AURA AT CROSSROADS

CIVIL CONSTRUCTION PLANS

ISSUE DATE: 08-06-2021	PROJECT #: 200823
DATE	REVISION COMMENTS
10-29-2021	PER COUNTY COMMENTS
01-13-2022	PER COUNTY COMMENTS

AURA AT CROSSROADS
SIGNAGE AND STRIPING PLAN

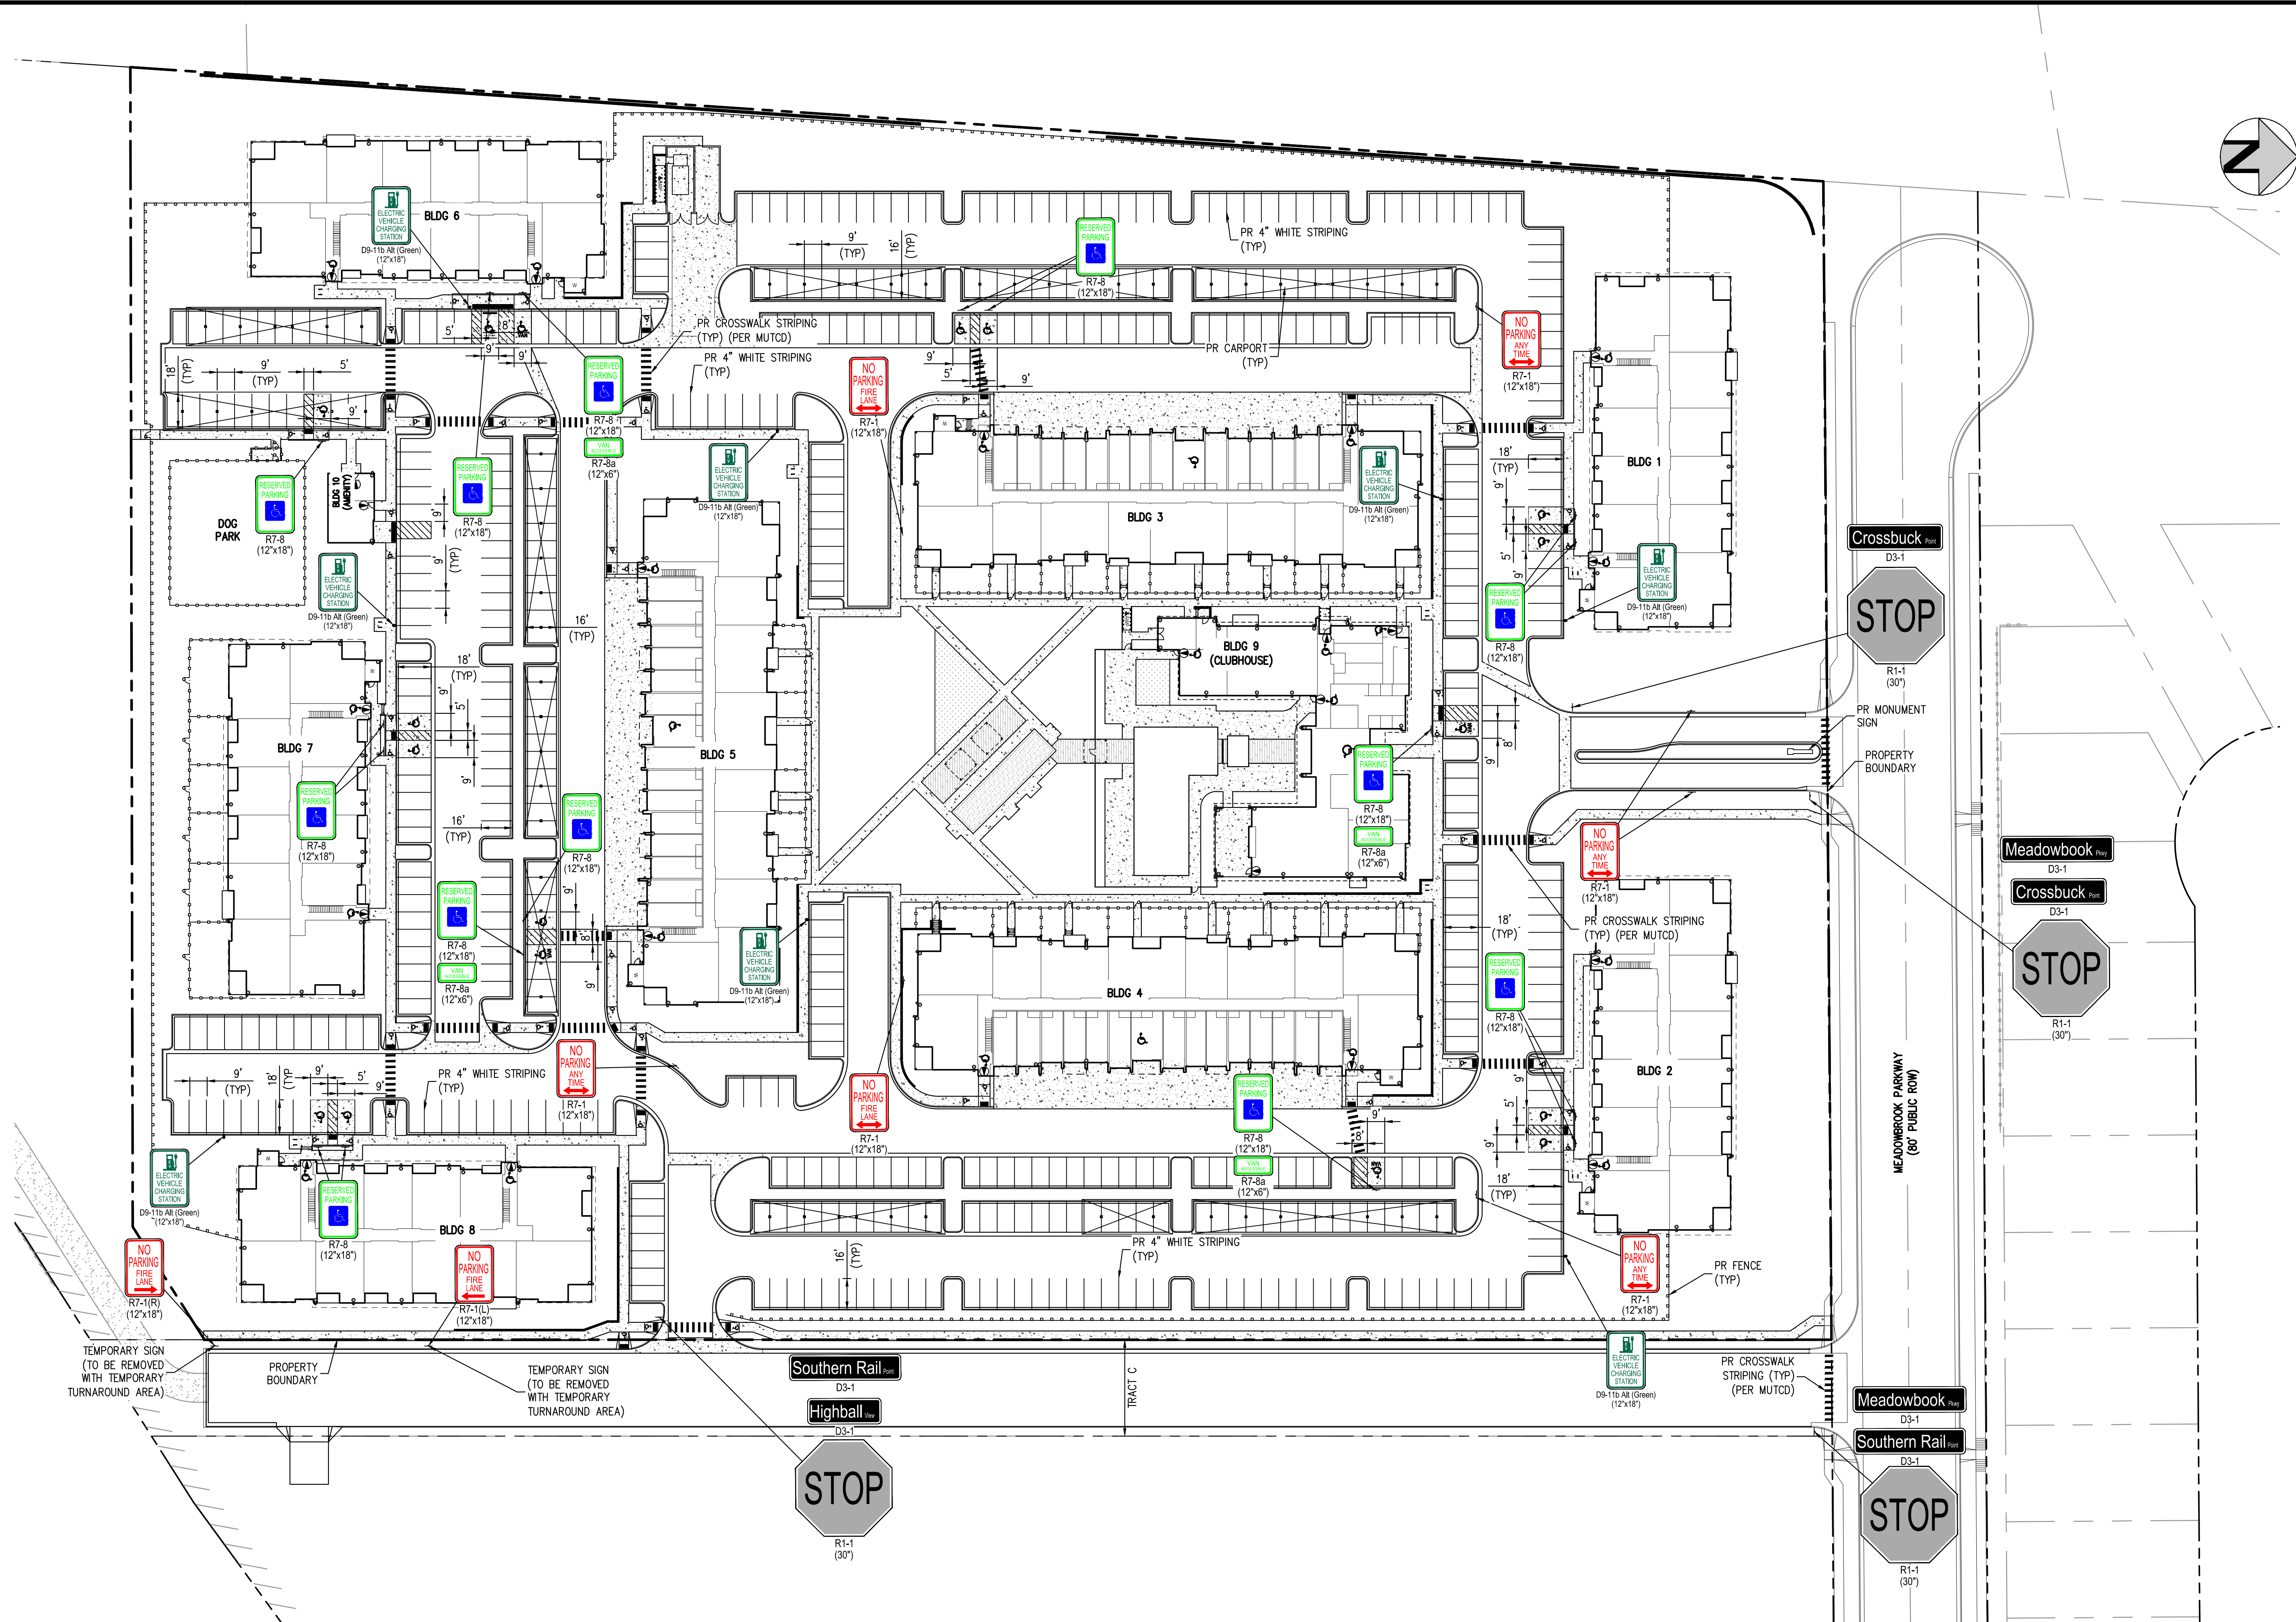
Please show striping for crosswalk per MUTCD.

AURA AT CROSSROADS
TRACT C - CENTERLINE PLAN & PROFILE

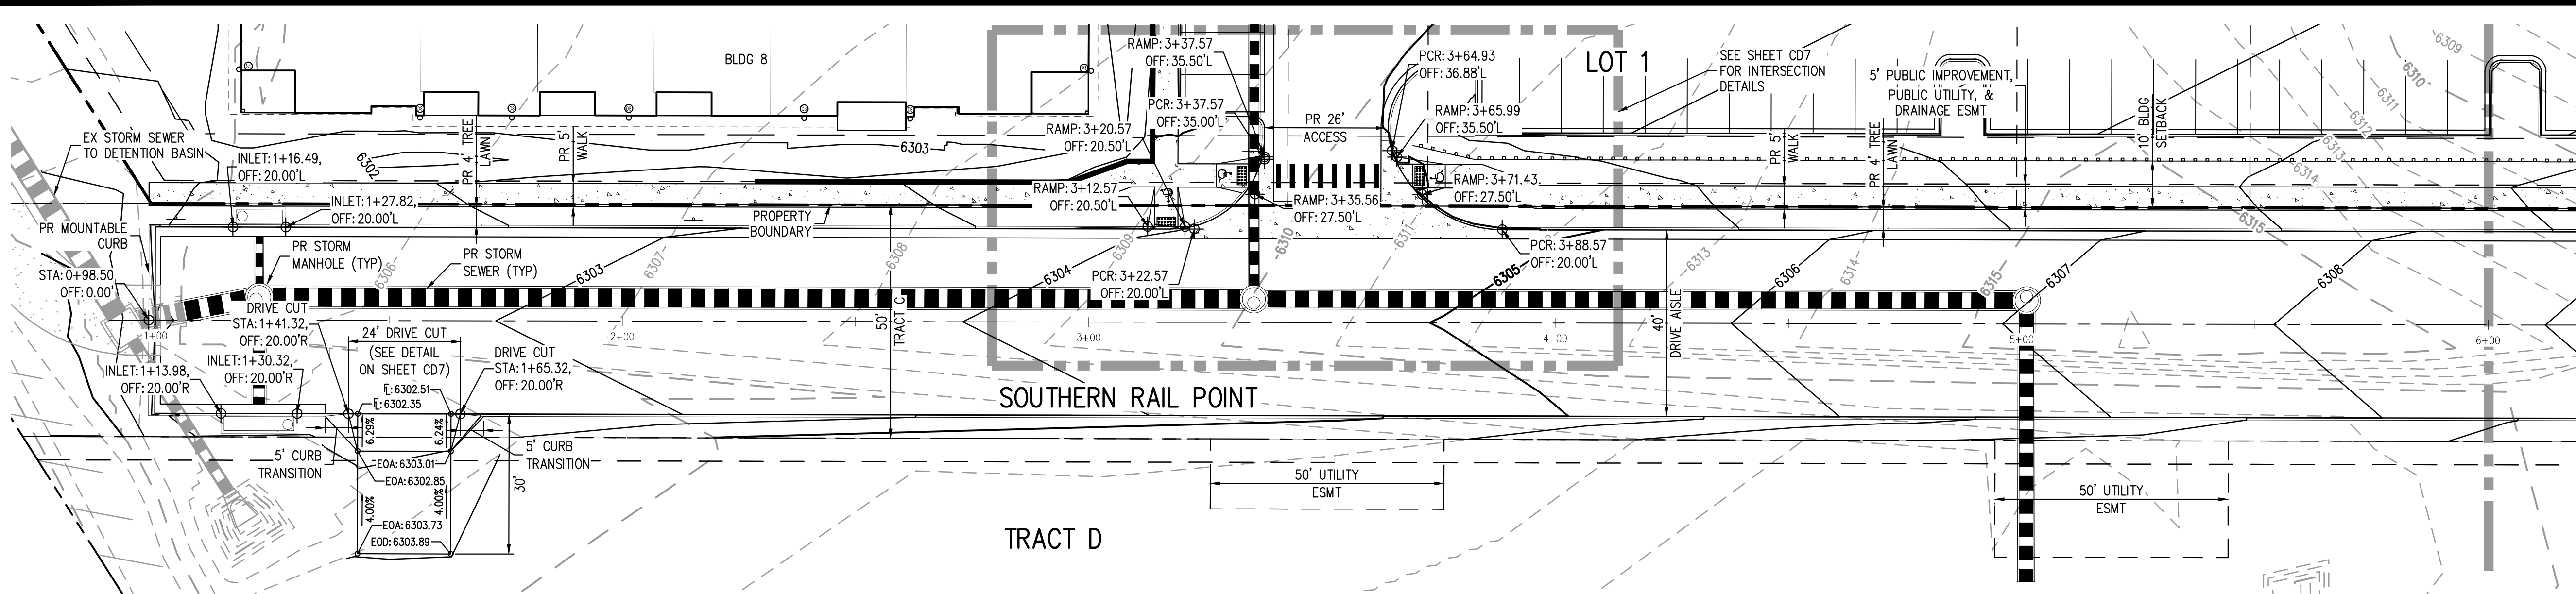
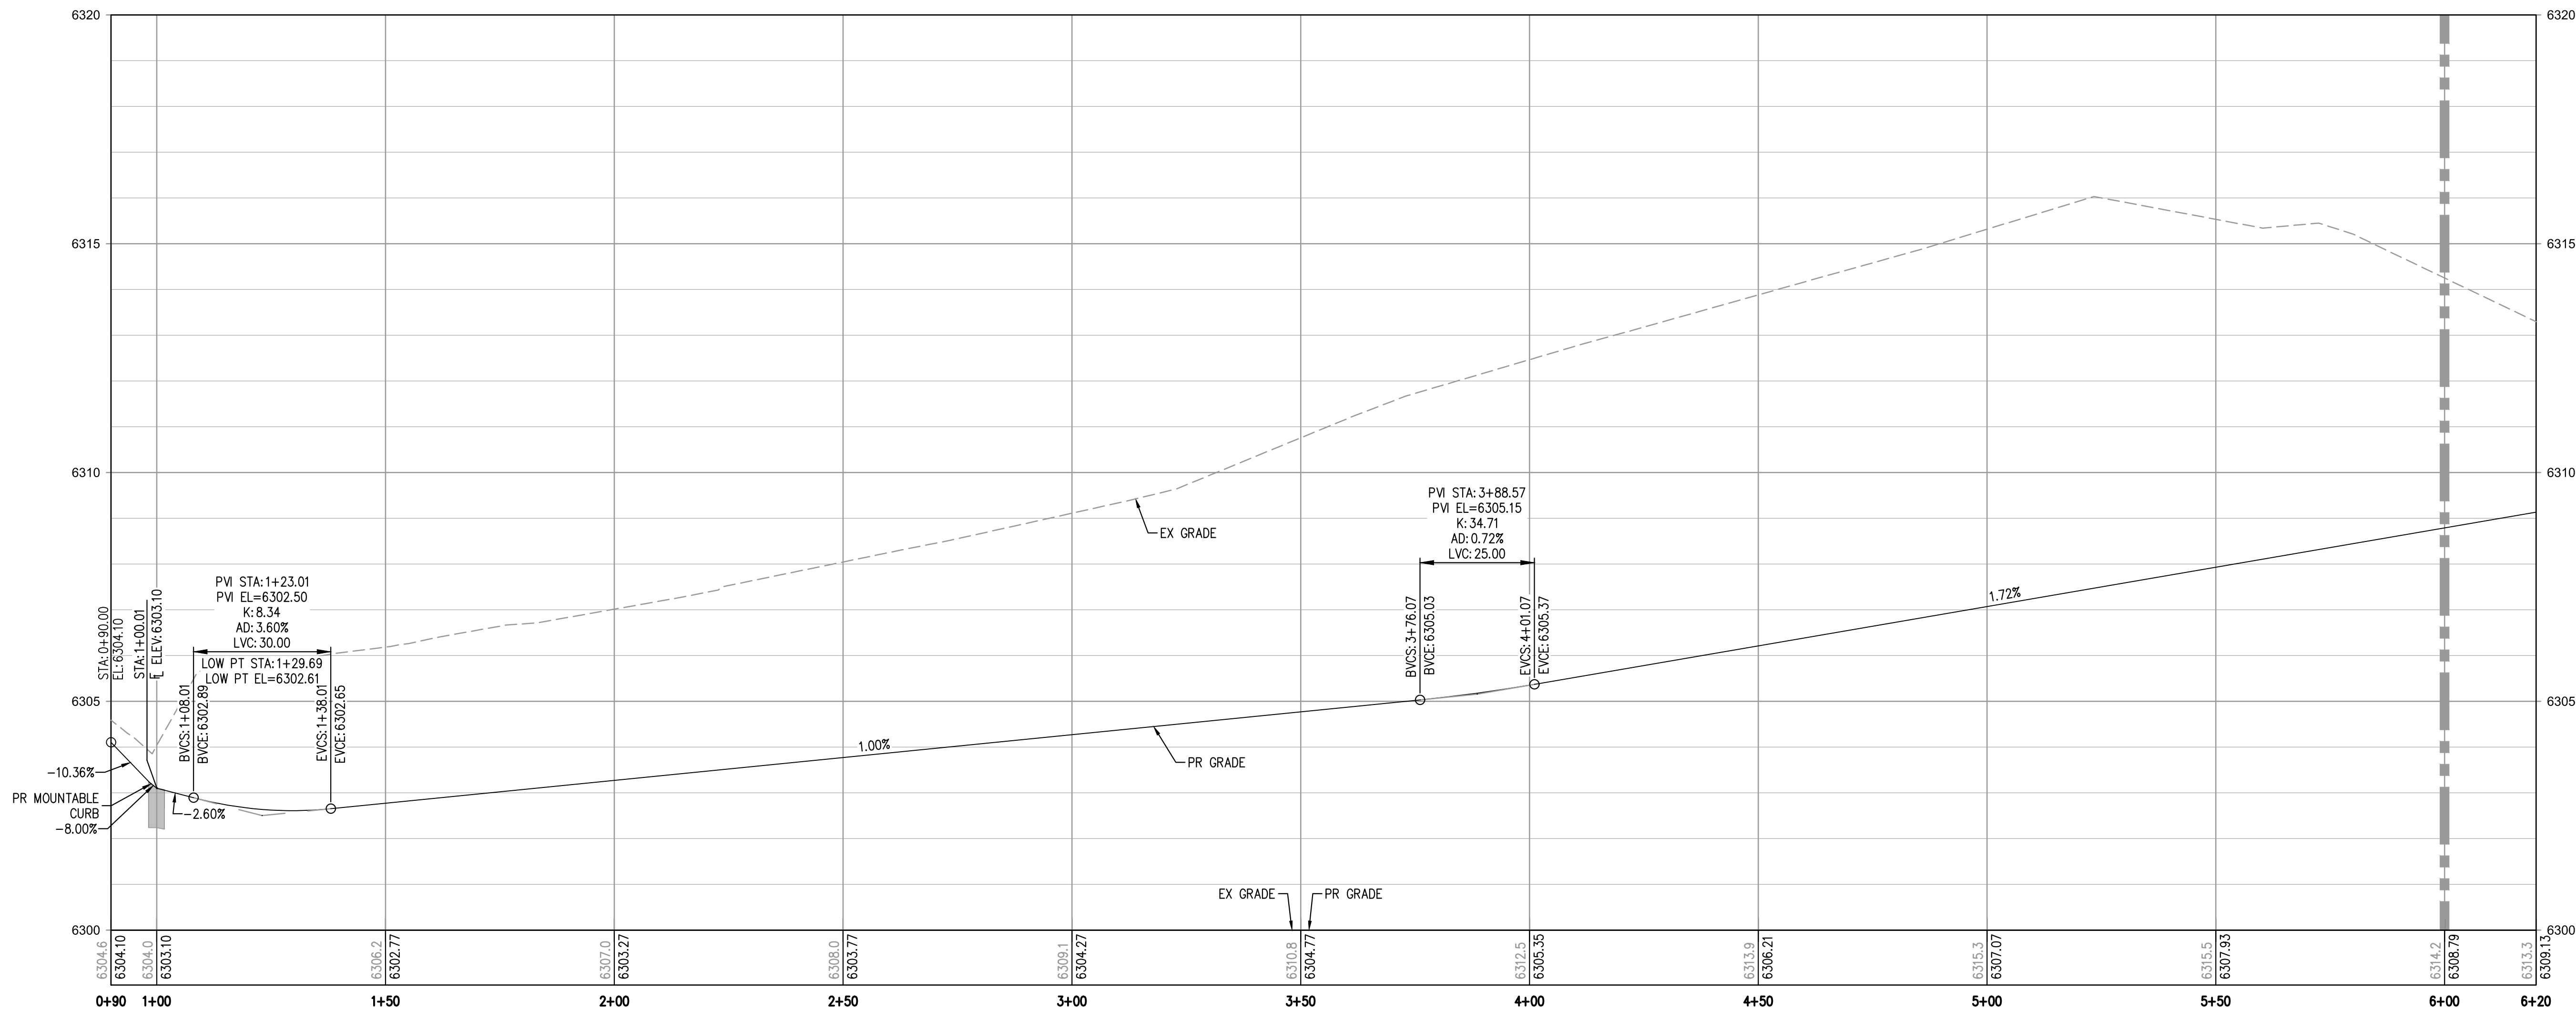
Please show modified hammerhead per conversation on 2/15/2022.
